Application for Planning Permission

Development: Erection of 1 No detached dwelling and integral garage. This site is in CIL Zone 4 and is CIL Liable as new dwelling.
Location: 47 Golden Avenue East Preston BN16 1QX

I regret that I am unable to accept your documents as a valid application until the following item(s) have been received or resolved :-

Drawing Title:
Side Elevations

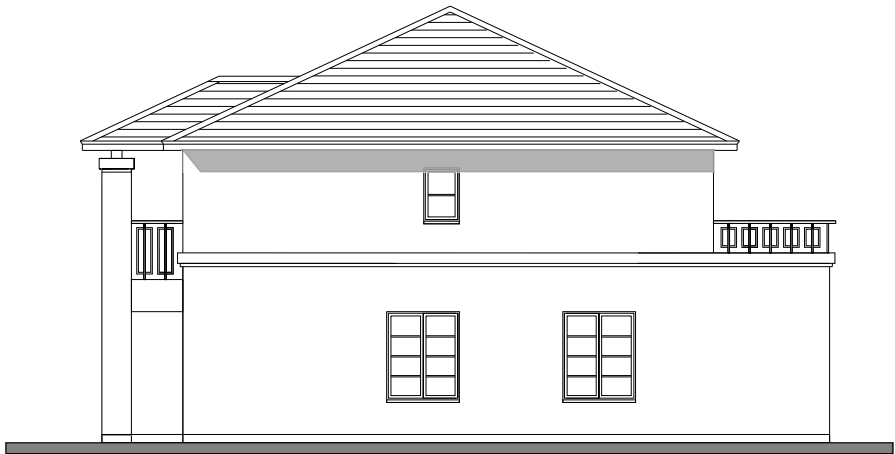
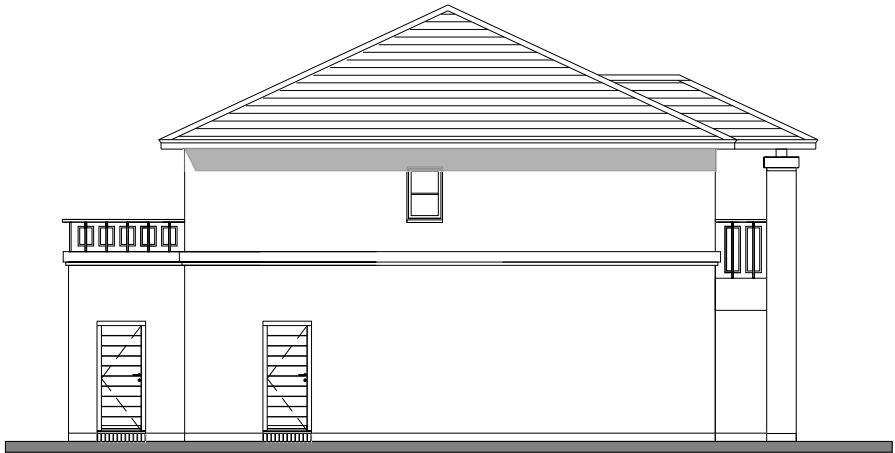
The ground floor plan and side elevation do not accord. Please amend accordingly.
